Our ref: NO/2019/112110/02-L01
Your ref: 3/2019/0840
Date: 18 December 2019

**EXTENSION TO EXISTING WORKSHOP AND CREATION OF PARKING AREA.
JAMES ALPE LIMITED LINCOLN WAY, CLITHEROE, LANCASHIRE, BB7 1QD.**

Environment Agency Position

PROPOSED SITE PLAN			
Site: Vehicle Repair Centre - Workshop Extension Lincoln Way Clitheroe			
Client: James Alpe			
Date: 24.09.19		Scale: 1:500/50 @ A2	
Project No: ALP/21 - Dwg 03		Drawn: AxK	
Amendments:

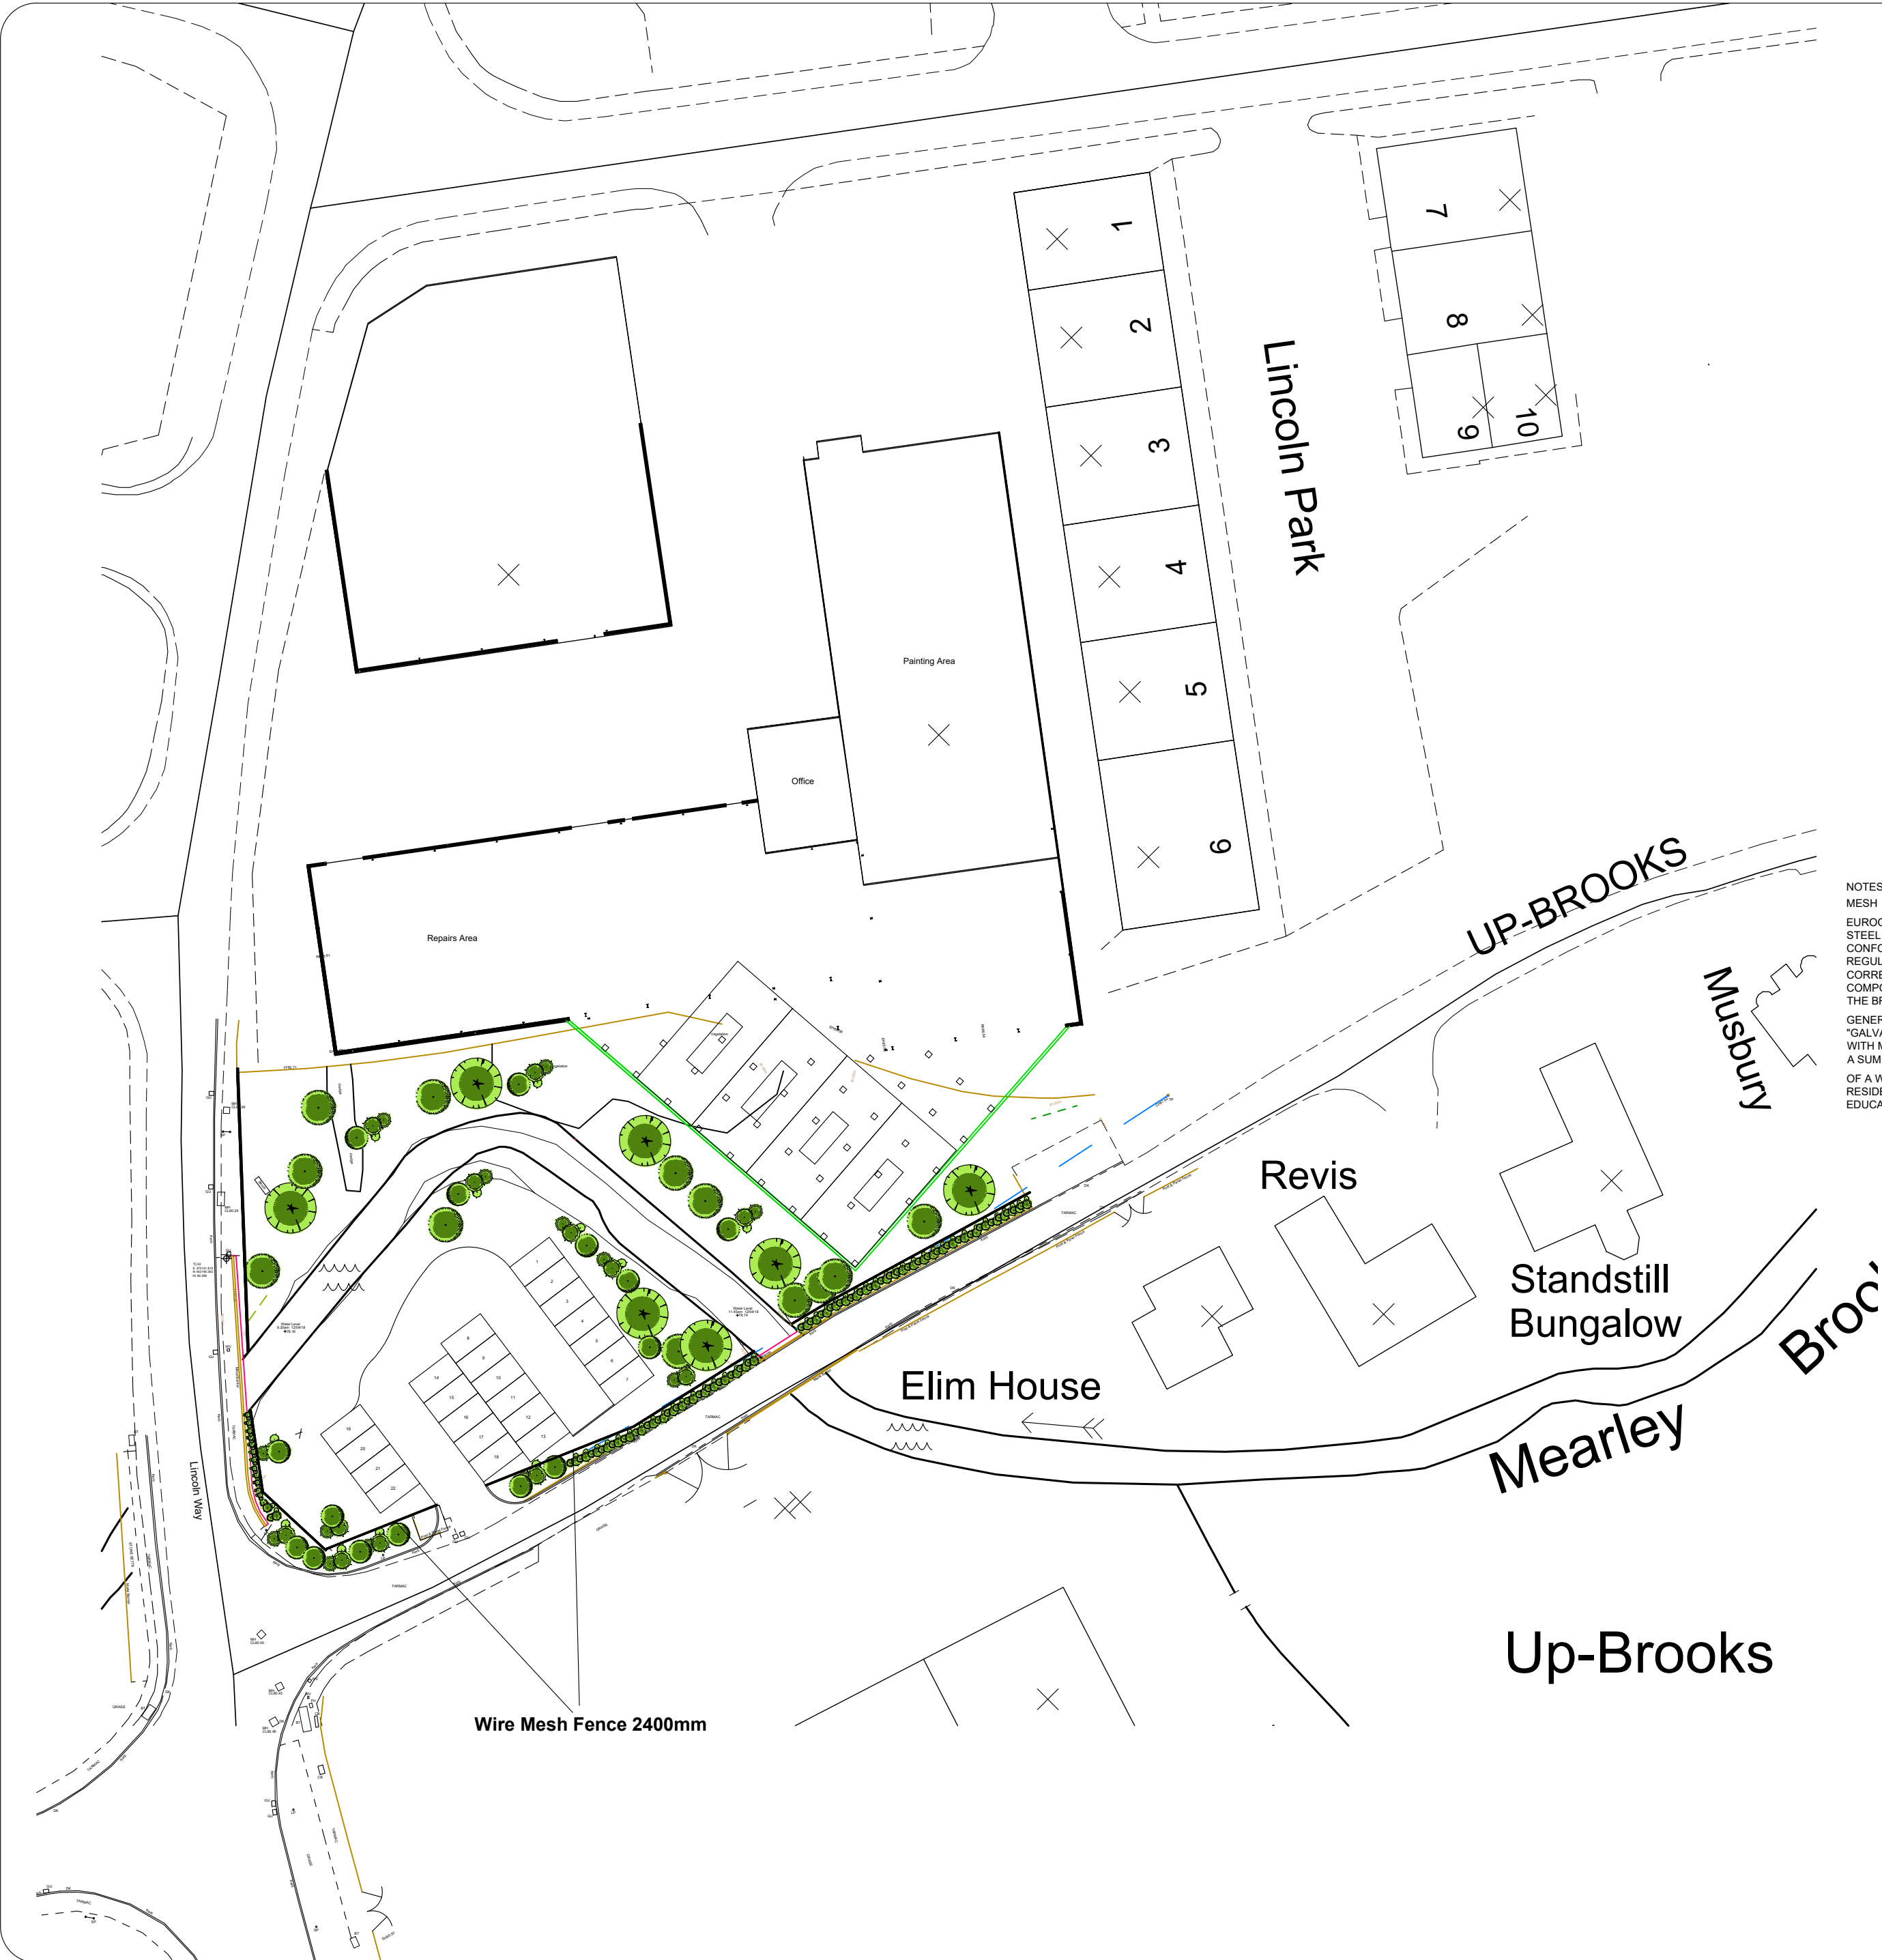
Unfortunately the minor alterations made to the previous FRA do not cover the requirements of a site specific flood risk assessment. Due to the absence of an acceptable Flood Risk Assessment (FRA) and the proposal to erect a fence and provide car parking within 8 metres of a Main River, we object to this application and recommend that planning permission is refused. As submitted, it is unlikely that we would grant a flood risk activity permit for this application

- Properly assess the increased flood risk associated with infilling the floodplain. The proposed car park within the floodplain will reduce the flood storage capacity of the river and will increase flood risk to adjacent properties. Infilling the floodplain will only be permitted if compensatory flood storage is provided and flood risk is not increased.
- Properly understand and assess the risks of erecting wire mesh fencing within the floodplain and next to the river. The proposed fencing will impede overland flood flow which will increase flood risk to adjacent properties.
- take the impacts of climate change into account

- The proposed development would restrict essential maintenance and emergency access to the Main River watercourse. The permanent retention of a continuous 8 metre wide unobstructed area is an essential requirement for future maintenance and/or improvement works.
- The proposed development would obstruct flood flows, thereby increasing the risk of flooding to adjacent properties
- The construction of the car park adjacent to the river may interfere with natural geomorphological processes and could be placed at risk of damage arising from channel migration/erosion.

To overcome our objection, the applicant should submit a revised FRA which addresses the points highlighted above.
